## Inspector's Report

### ABP-322098-25

<b>Development</b>	Construction of an Anaerobic Digestion facility along with all associated site works.
<b>Location</b>	Country Crest, Collinstown, Lusk, Co. Dublin
<b>Planning Authority</b>	Fingal County Council
<b>Planning Authority Reg. Ref.</b>	F24A/1162E
<b>Applicant(s)</b>	County Crest ULC
<b>Type of Application</b>	Permission
<b>Planning Authority Decision</b>	Refuse Permission
<b>Type of Appeal</b>	First Party vs. Refusal
<b>Appellant(s)</b>	County Crest ULC
<b>Observer(s)</b>	<ol style="list-style-type: none"><li>1. Peter Foley</li><li>2. Miriam &amp; John McLoughlin</li><li>3. Roisin &amp; Martin Murphy</li><li>4. An Taisce</li><li>5. Ray McDonnell</li><li>6. David Mulcahy &amp; Others</li></ol>

AREA#6

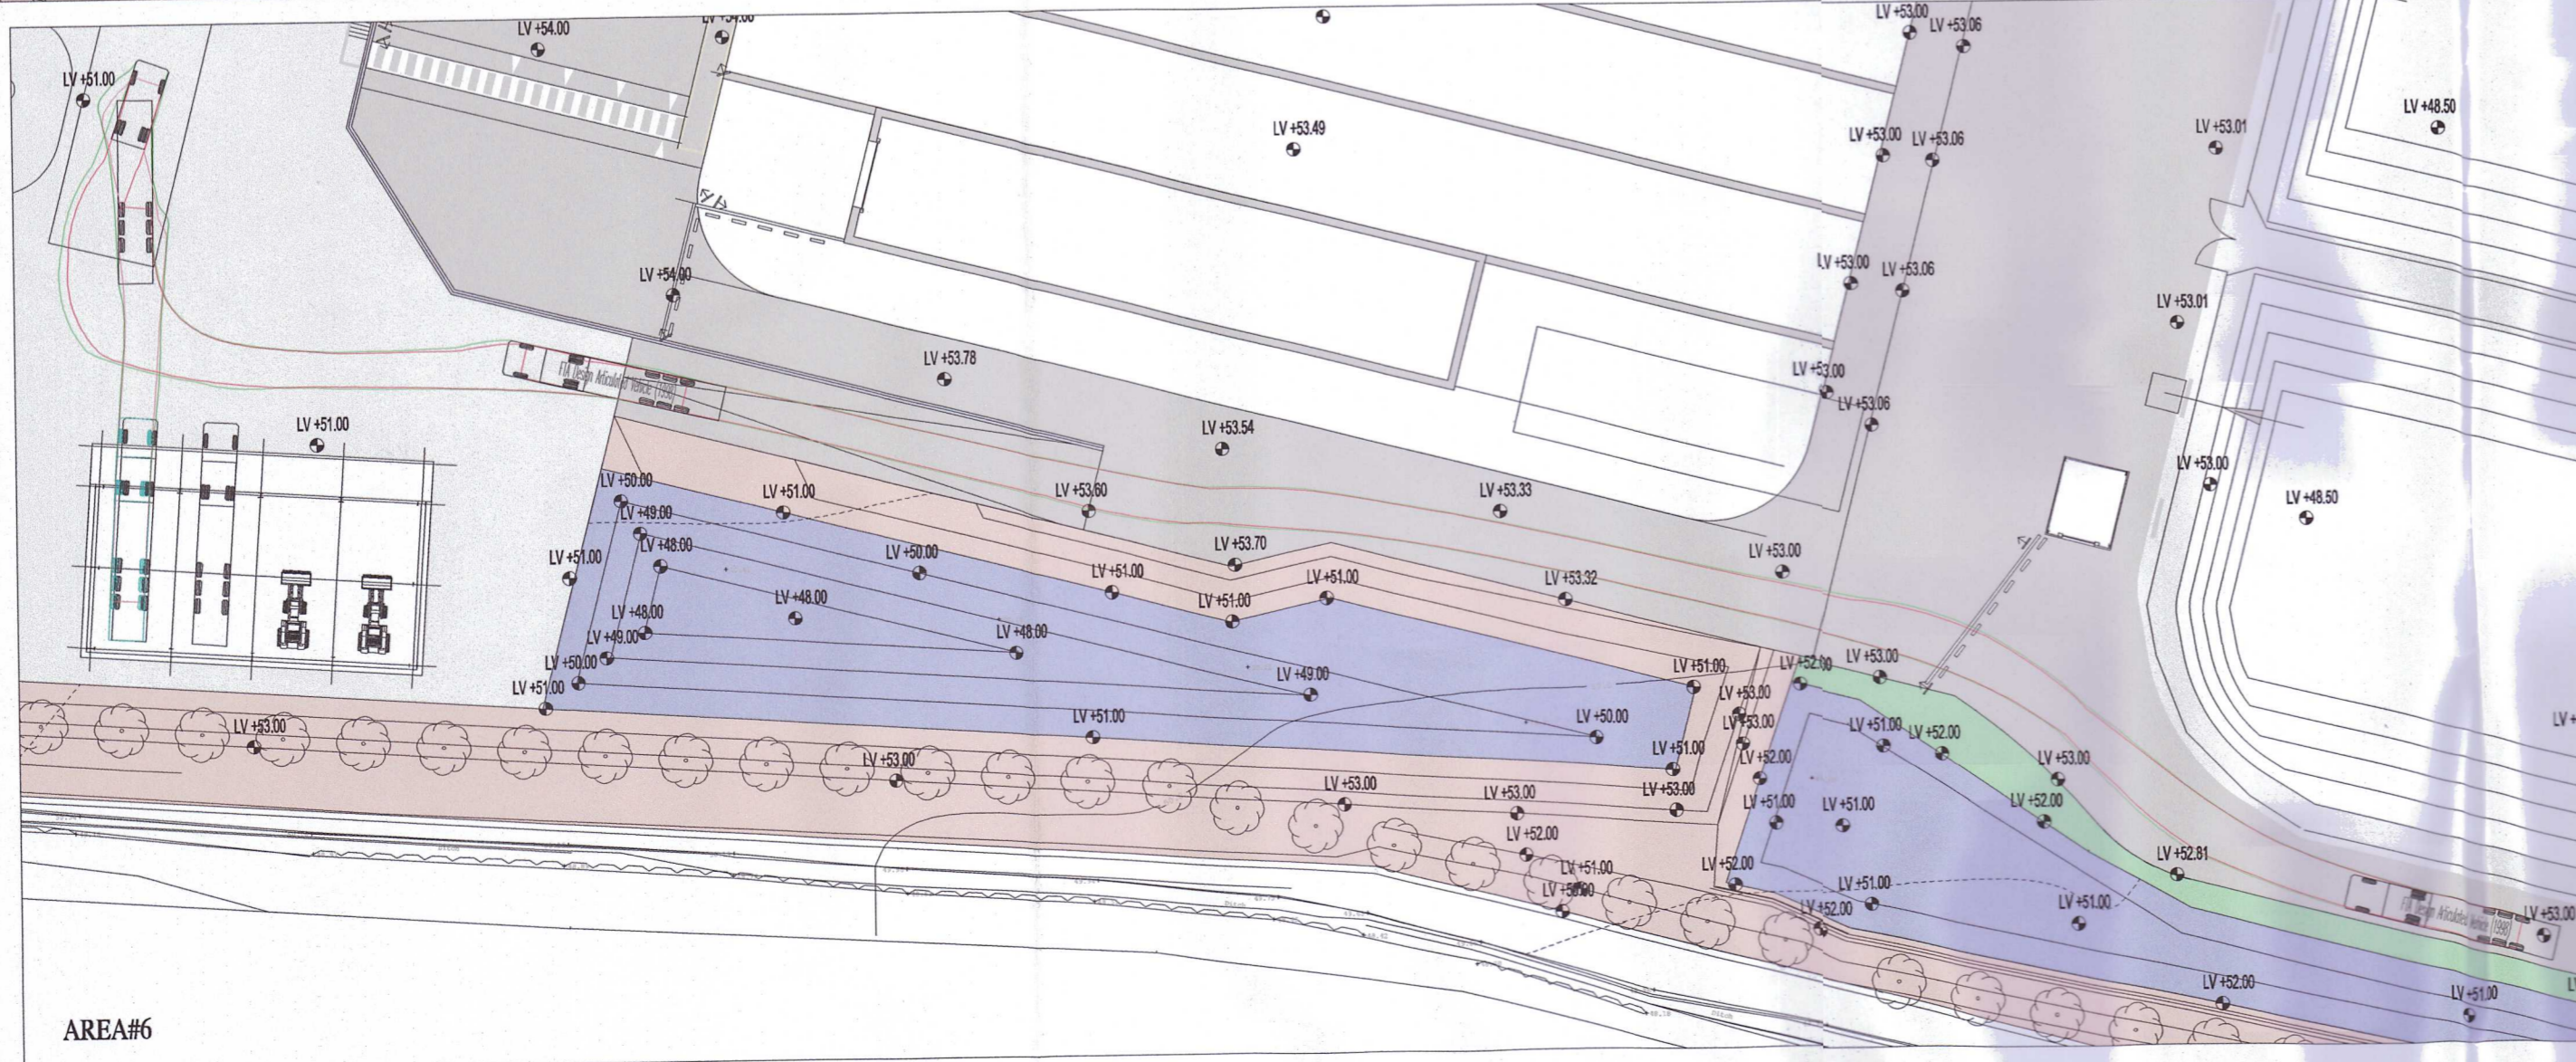
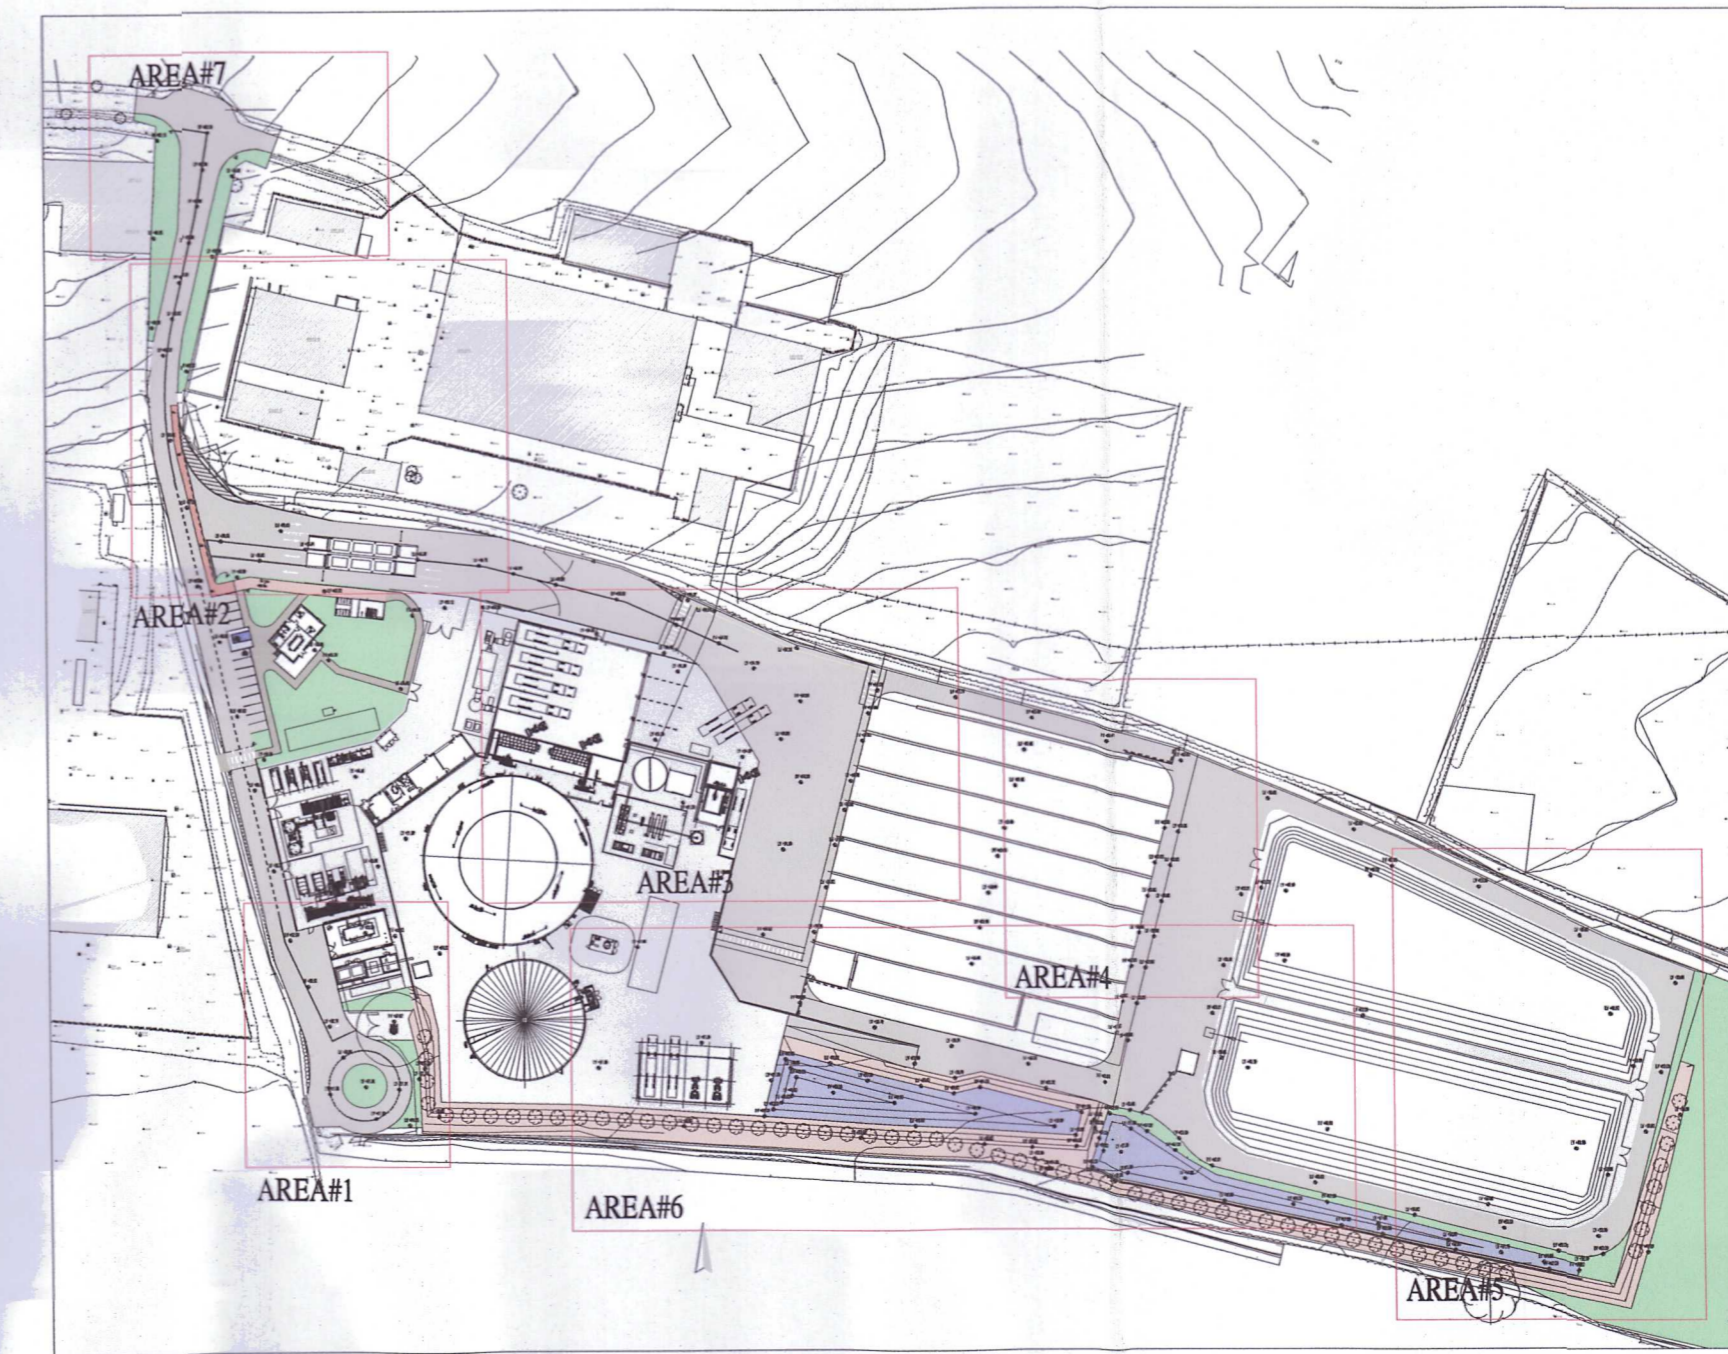
- No standalone Transport Assessment was submitted. Sections 4.4.5 and 11.3.6 of the EIAR deal with traffic impacts and have been reviewed by the FCC Transportation Planning section (as follows).
- There are concerns about the pedestrian movement proposal in terms of layout, width, at-grade level, etc., and that it would not protect vulnerable pedestrians in

close proximity to difficult articulated vehicle movements. The current format is considered a traffic hazard.

- A Road Safety Audit (RSA) has not been provided as is appropriate. The proposal would not protect vulnerable pedestrians in close proximity to difficult articulated vehicle movements. The current format is considered a traffic hazard.

LONG STAY BIKE SHELTER - PLAN
SCALE 1:50

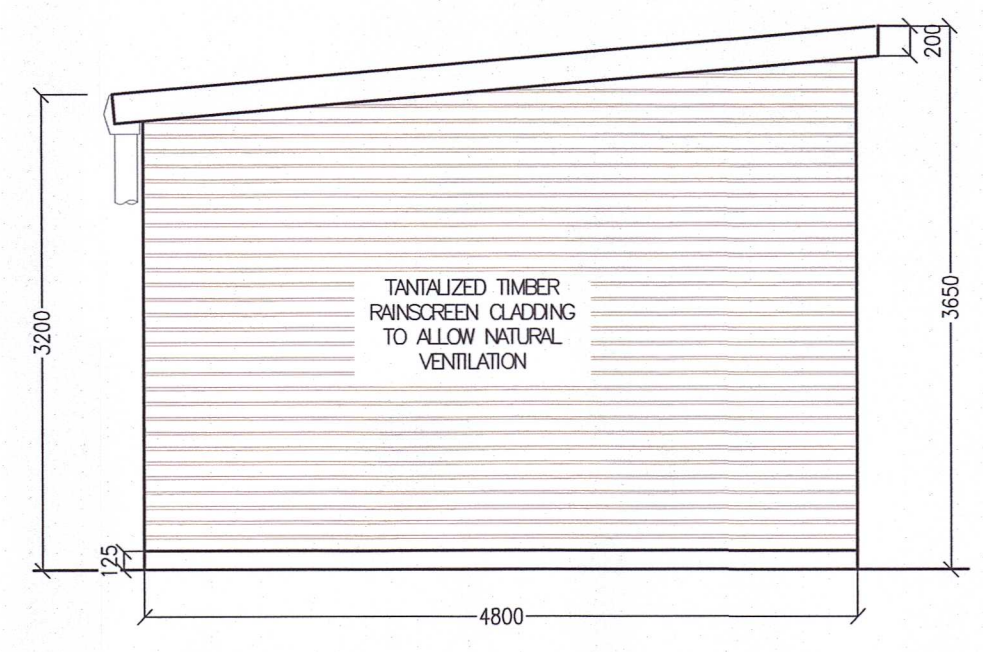
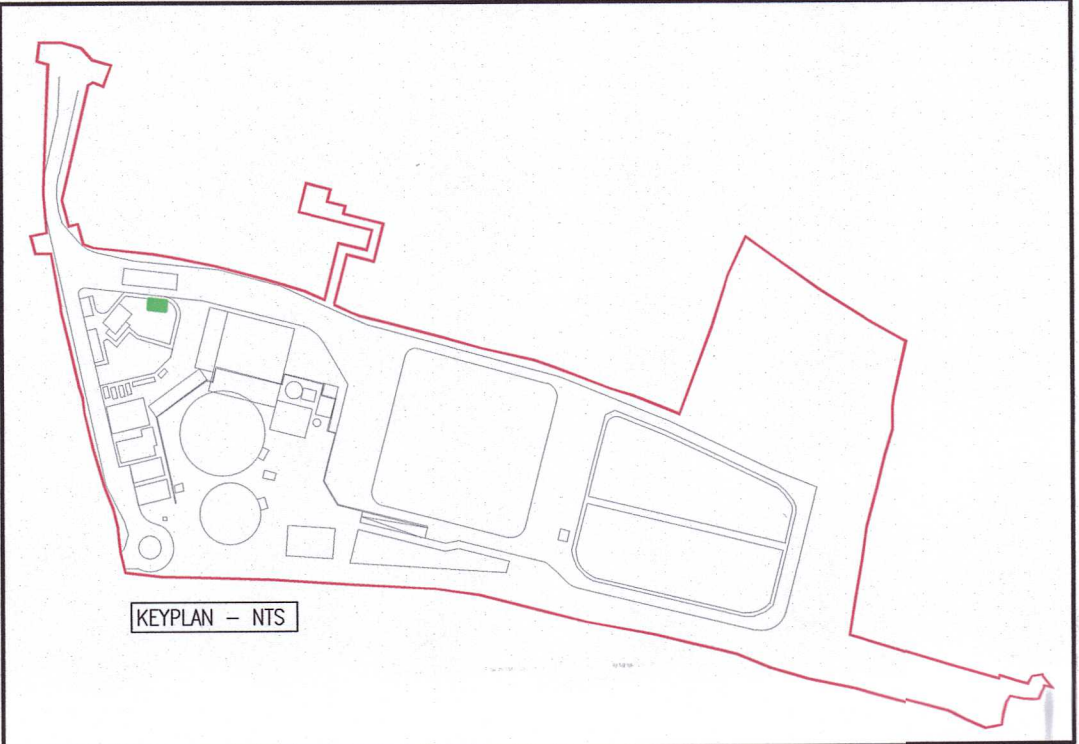
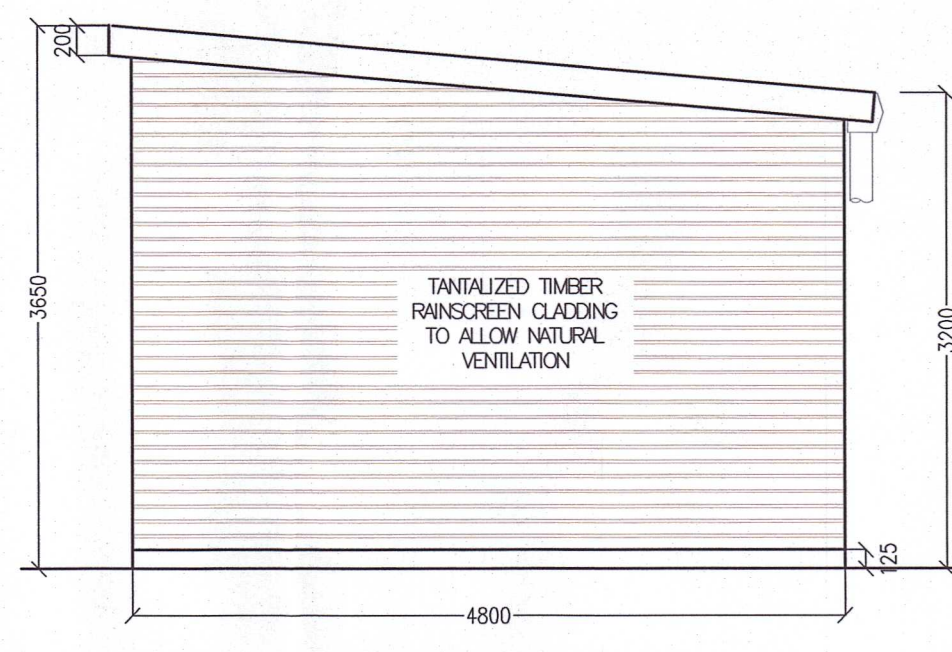
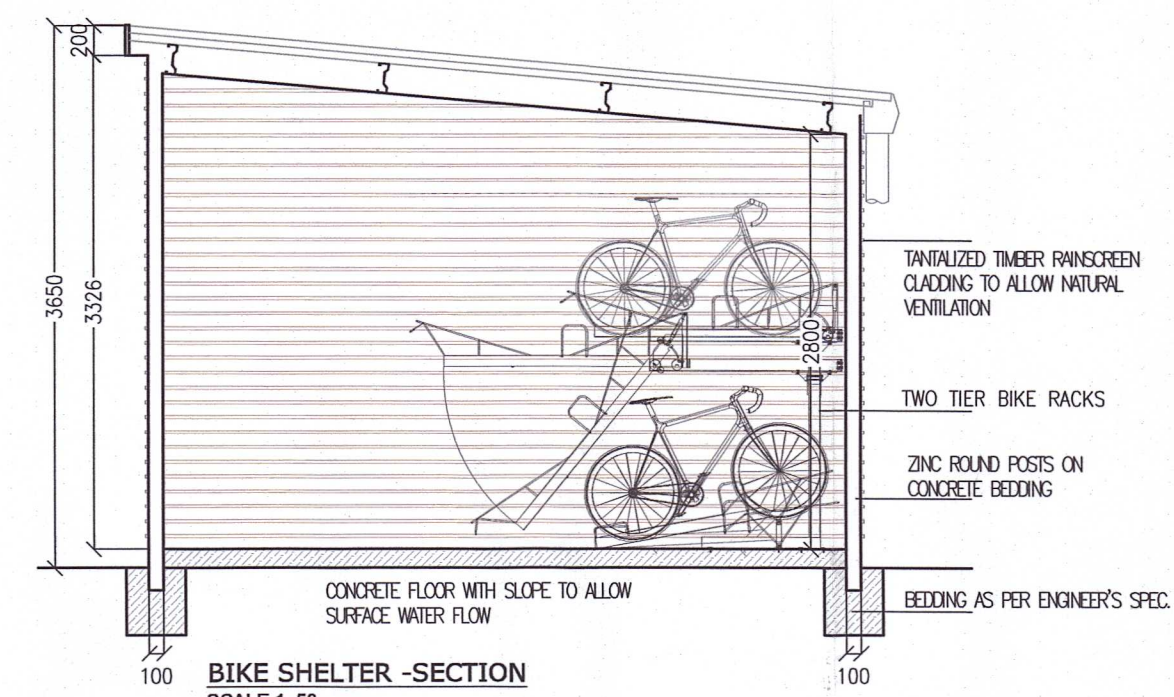
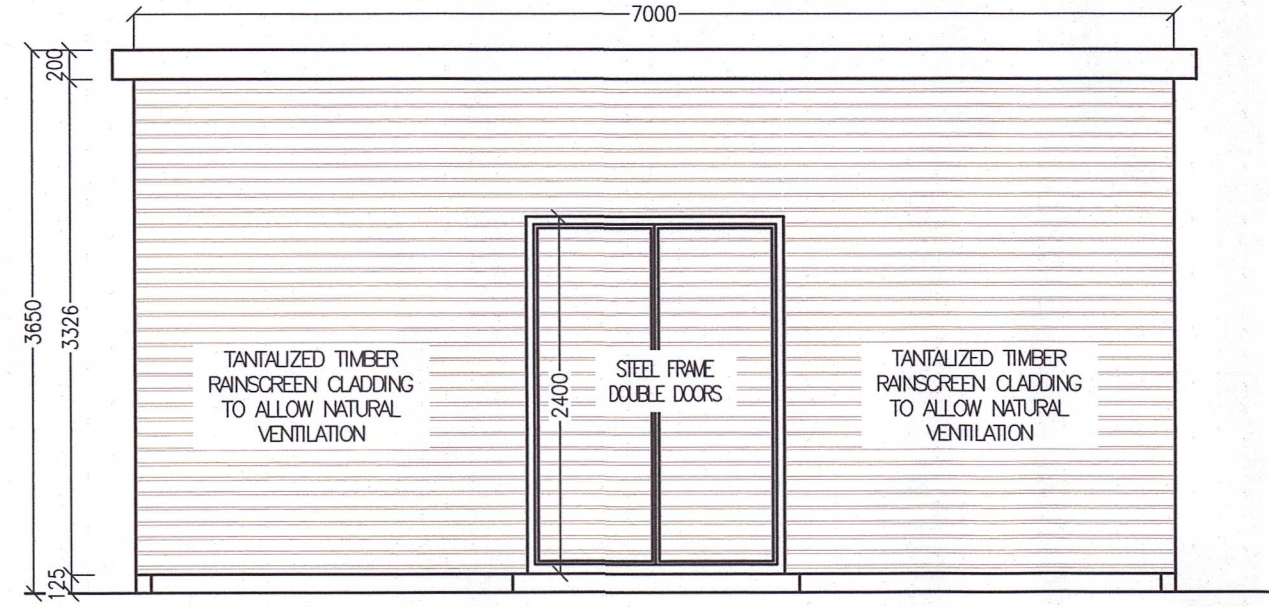
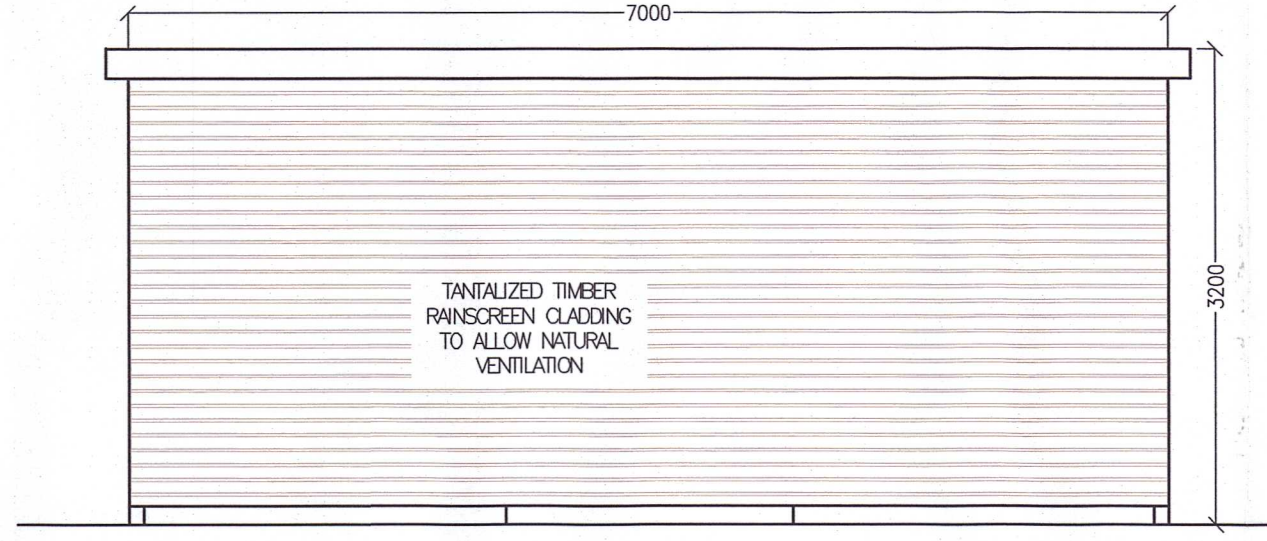
- The location of the bicycle shelter would cause a conflict between bicycle and vehicular traffic and result in a traffic hazard. The quantity of bicycle parking should also be in accordance with the CDP and should be designed to accommodate long-stay parking.
